Development Referral No. DN20/0063

Proposal: Environmental Impact Statement (EIS) for alterations and additions to President Private Hospital (SSD-10320).

Property: 369-381 President Avenue, Kirrawee

Map Title / Figure:
PMF Critical Storm Duration
Proposed Condition Water Level (mAHd) & Water Depth (m) - (Viewport 1)

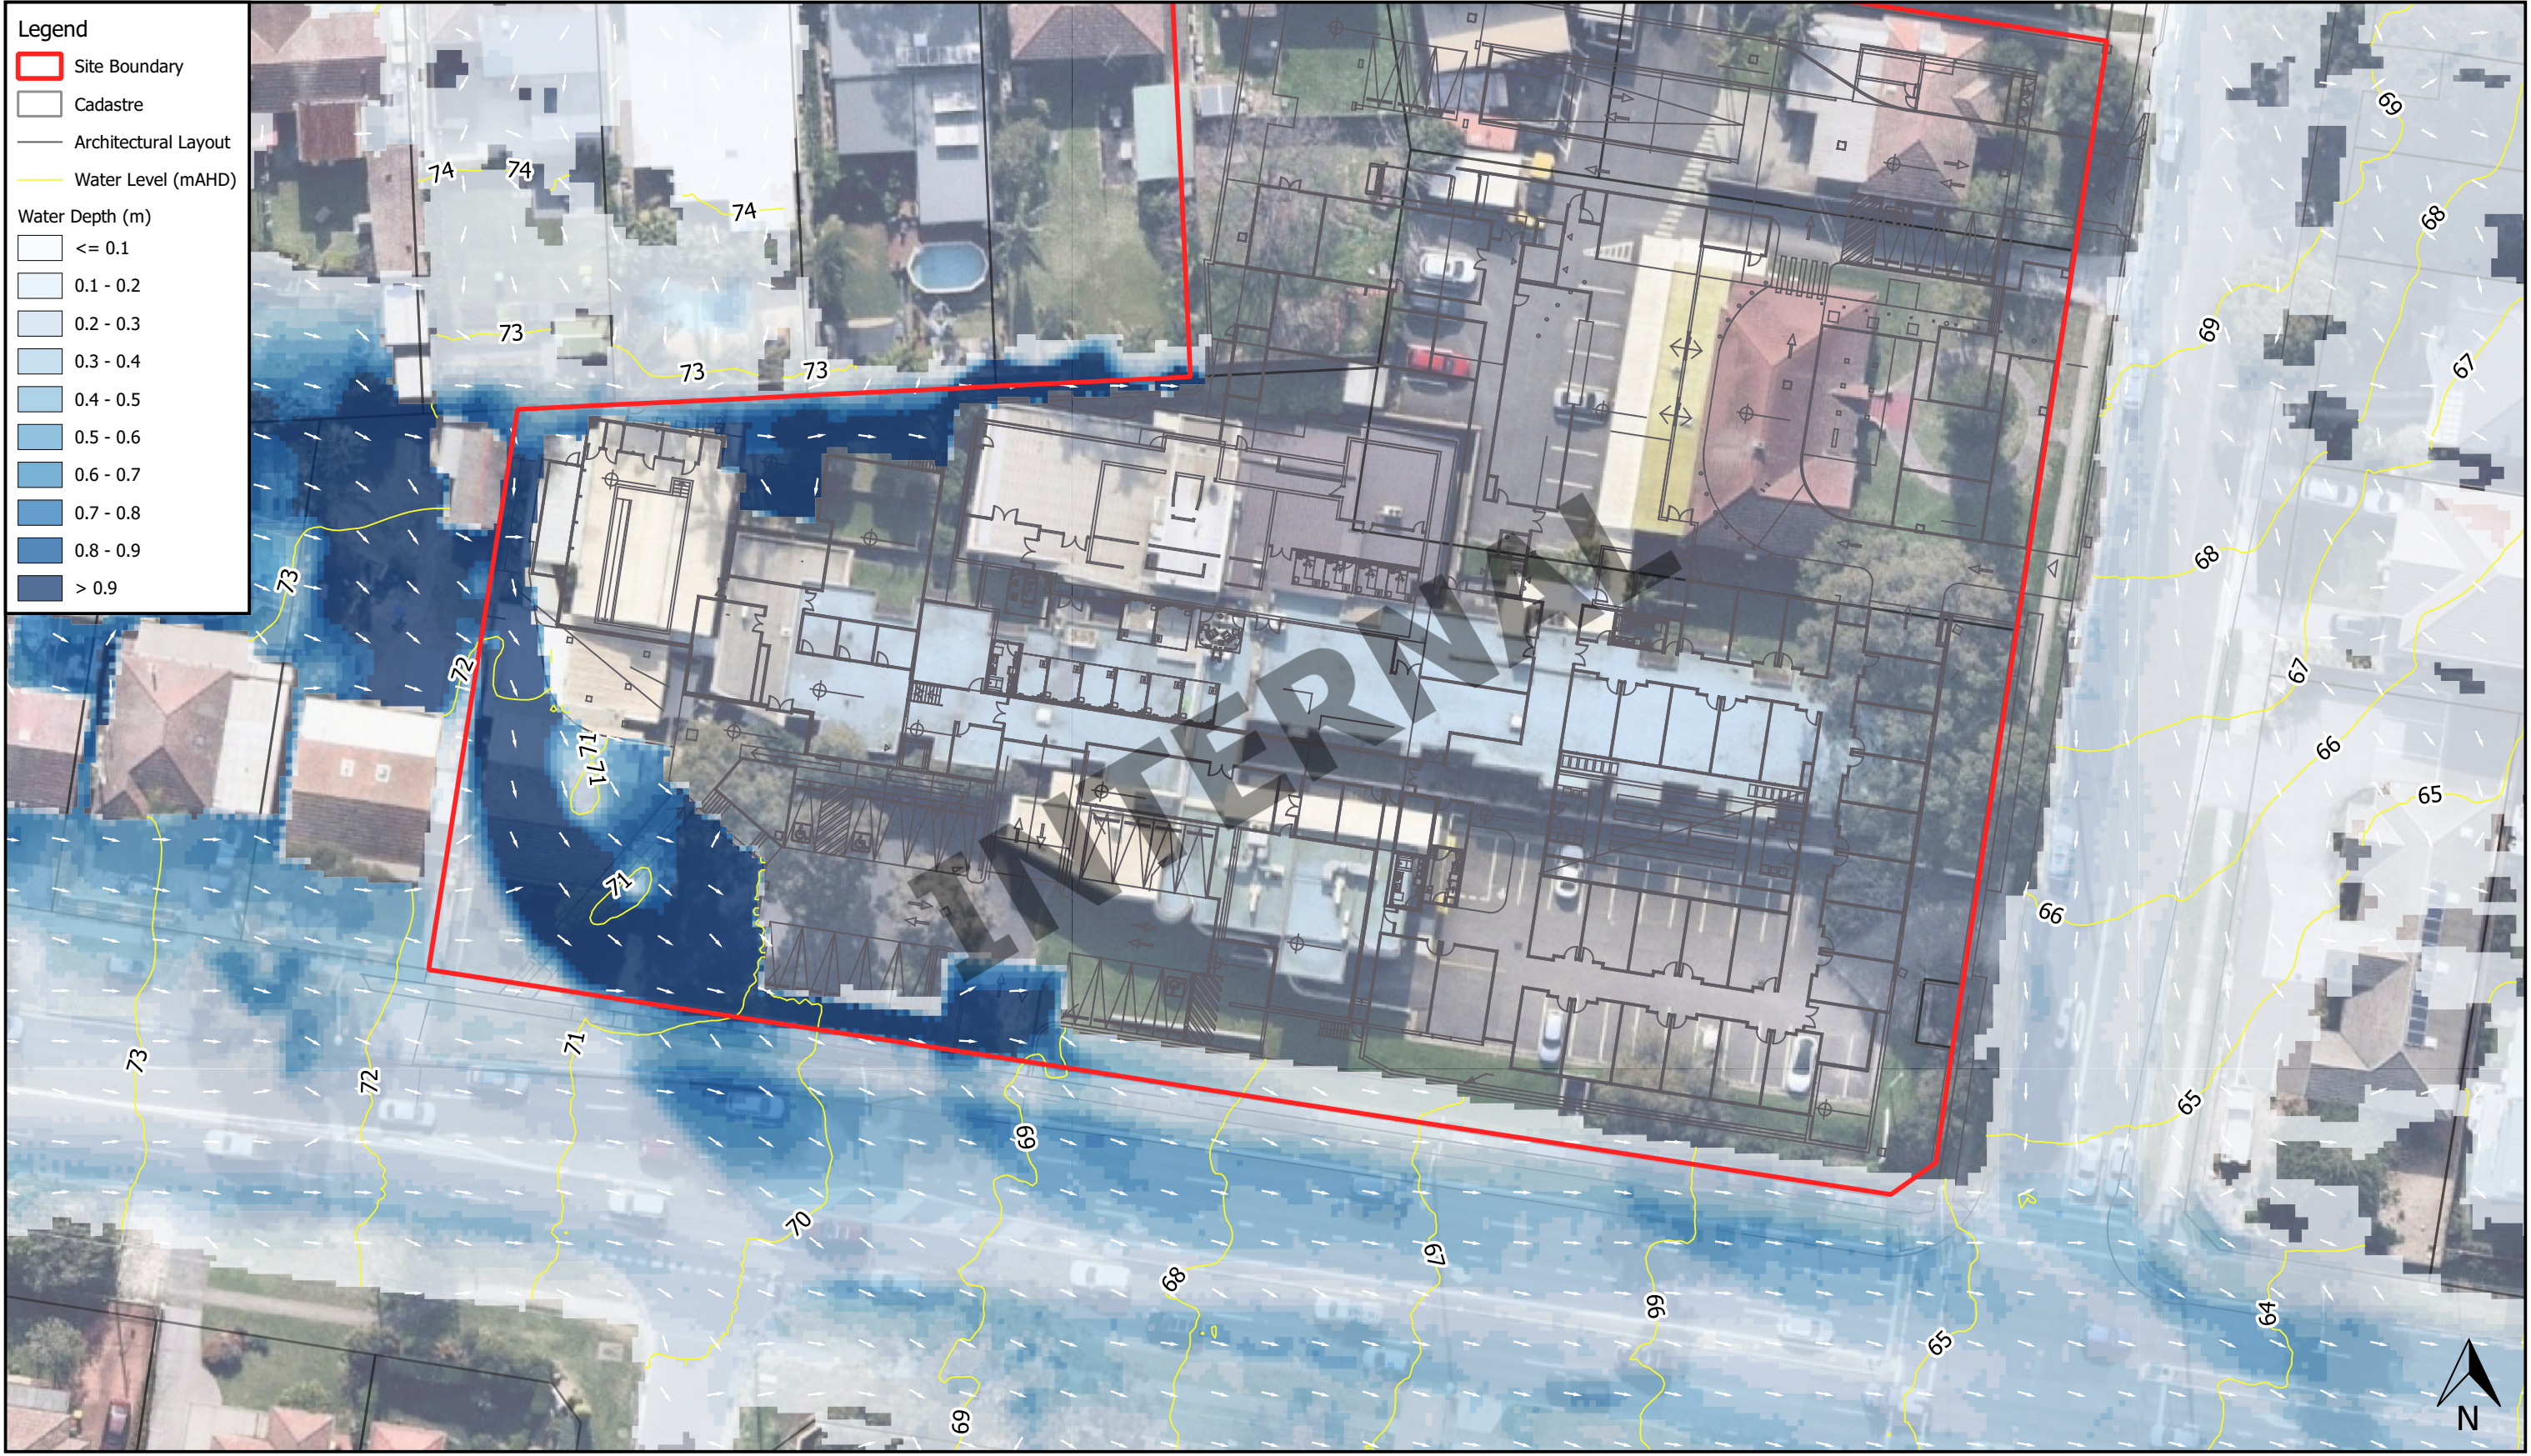
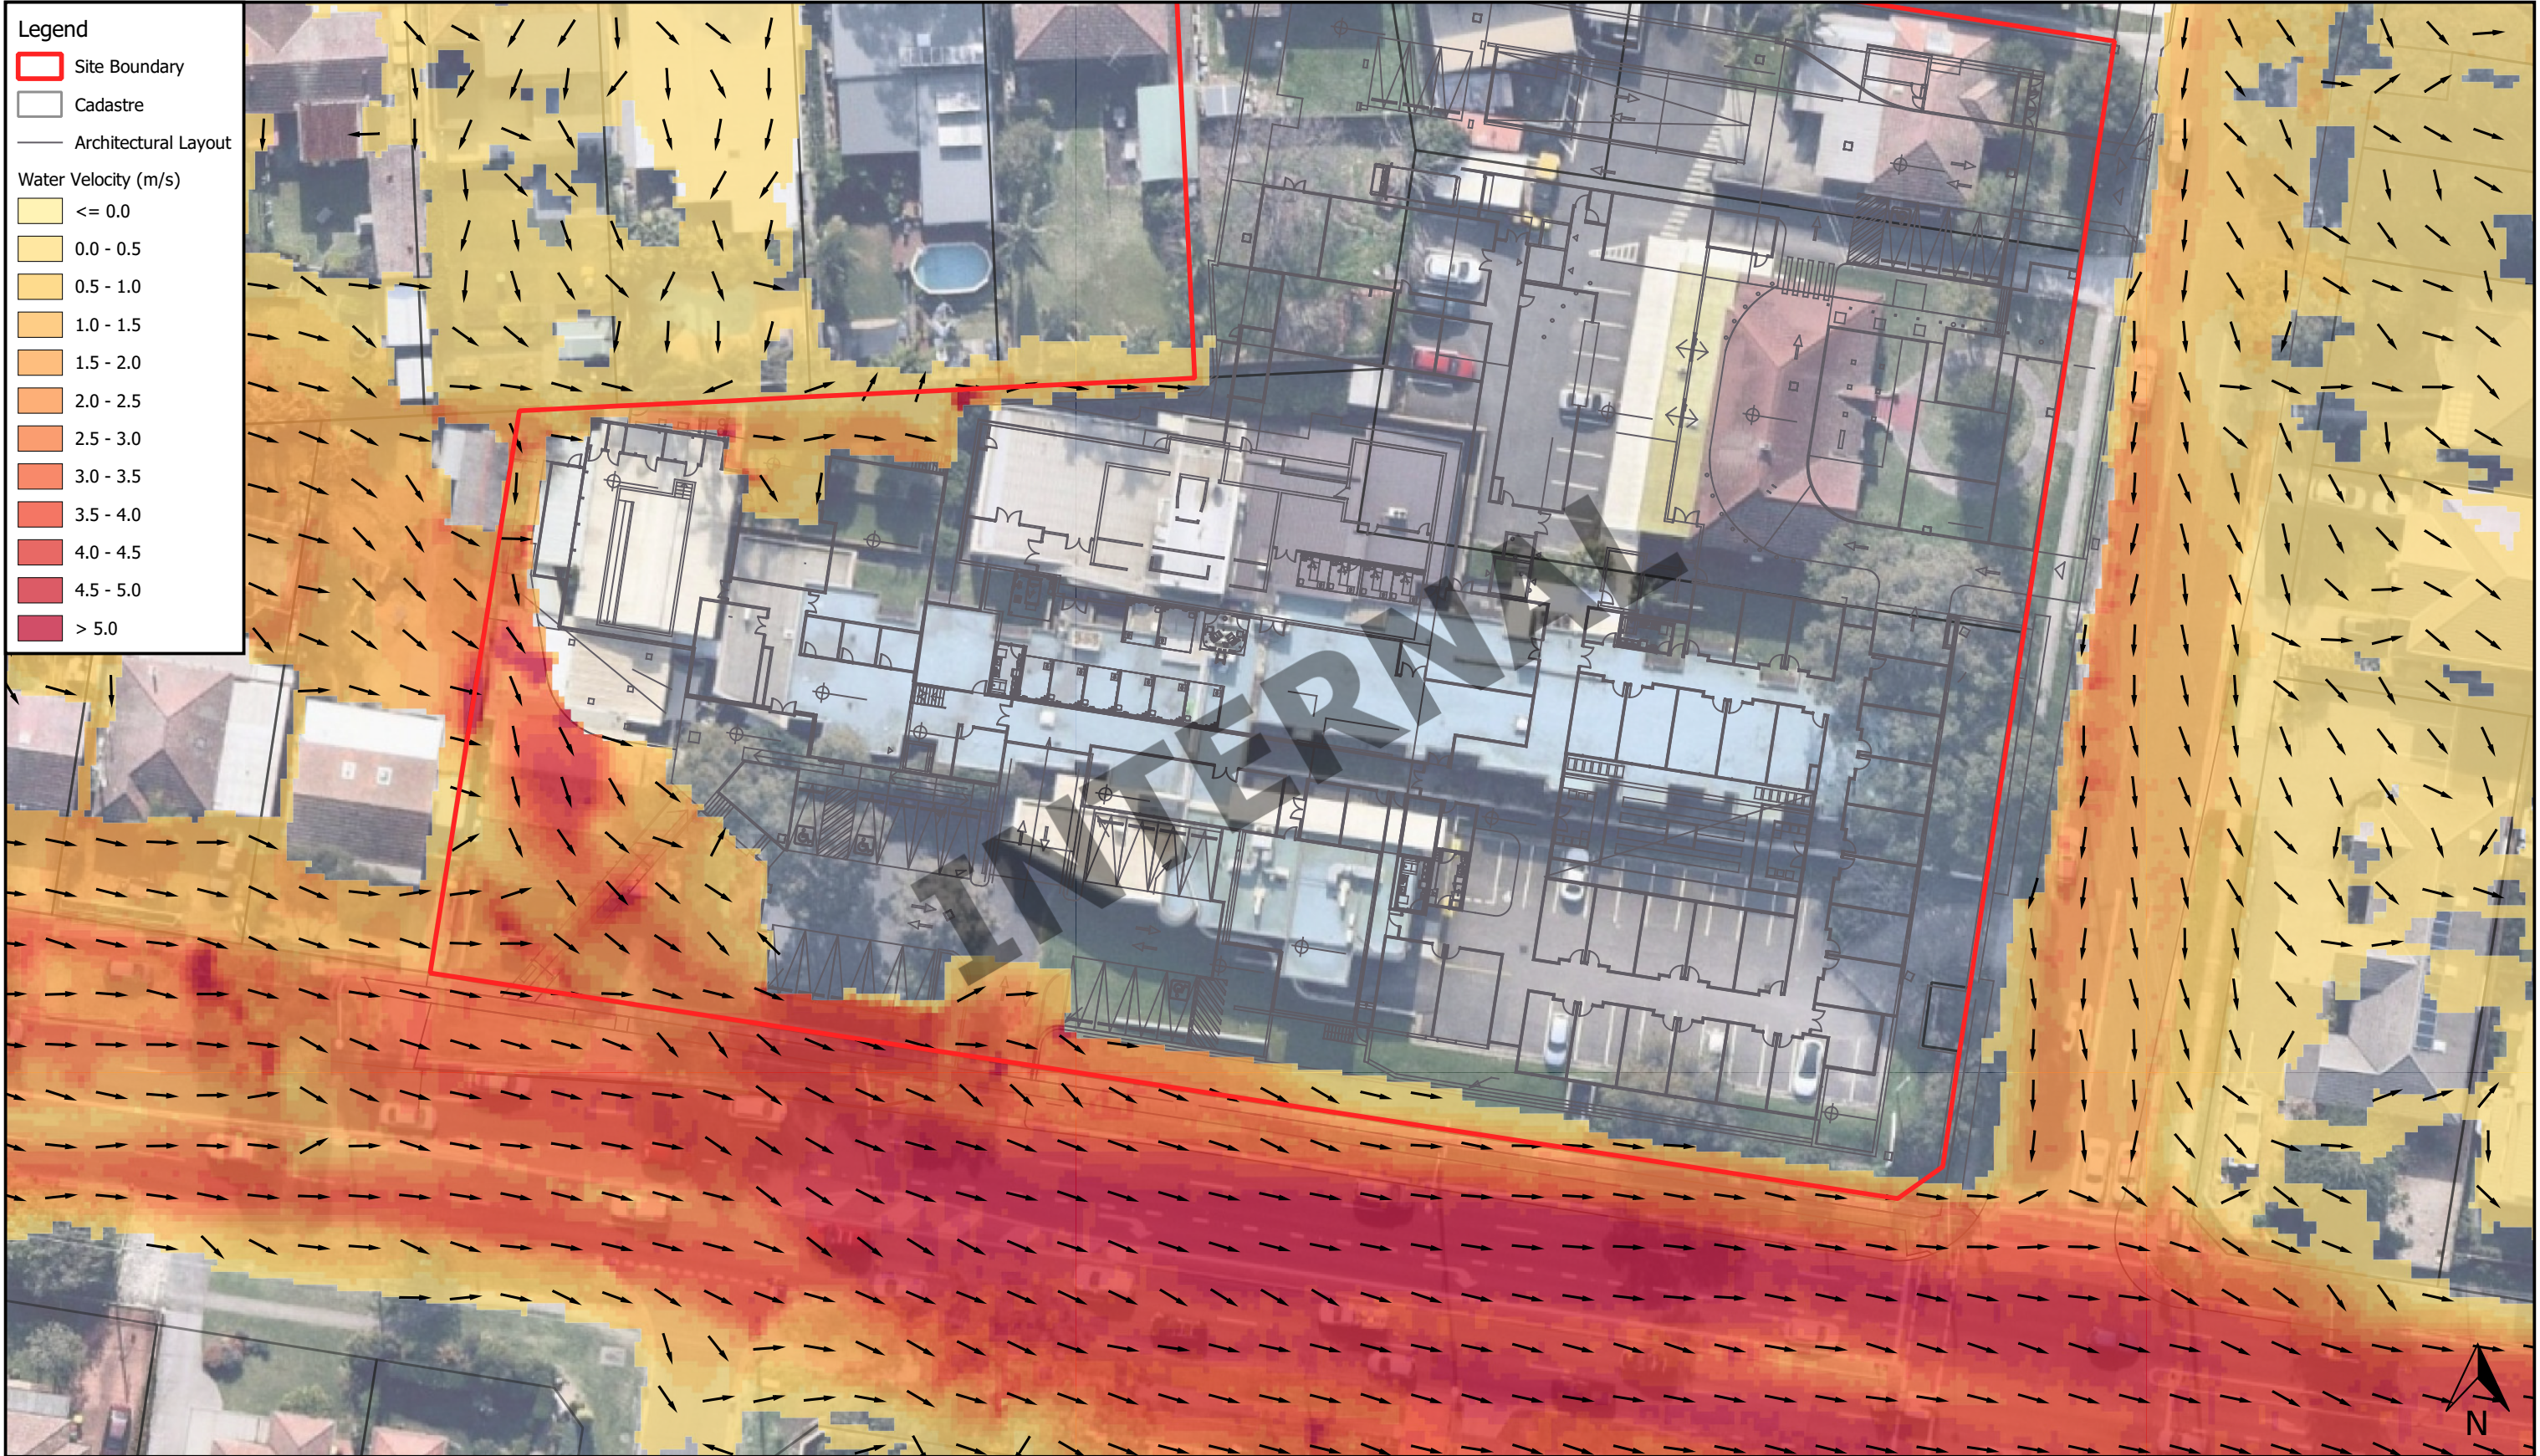
4. The hydraulic model does not account for Council's requirement for all inlet pits to be assumed 50% blocked.
5. The flood maps show flooding of the proposed car park in the PMF. Given the proposed development is an essential facility, greater protection from flooding is required. Hence, the basement driveway crest must be raised to the PMF level.

10. The flood maps show high hazard flooding of the proposed open car park in the PMF. Given the nature of the development, the open car park should be elevated so that it is not exposed to hazard causing damage to vehicles, hence should not fall within a hazard category higher than H2.

11. The crest of the driveway providing access to the basement should be elevated to the PMF level to provide additional protection.
12. Details of the proposed channel/swale should be provided and must be consistent with what has been modelled. Additionally consideration should be made to continuing the channel to the east toward the intersection at Hotham Rd and President Ave. In doing so, the channel should contain high hazard flooding within the property for an extended length before discharging onto the carriageway. This would reduce the risk to life and property damage within President Avenue. The applicant should consult with the SES and NSW Police to confirm that this would assist during a flood emergency.
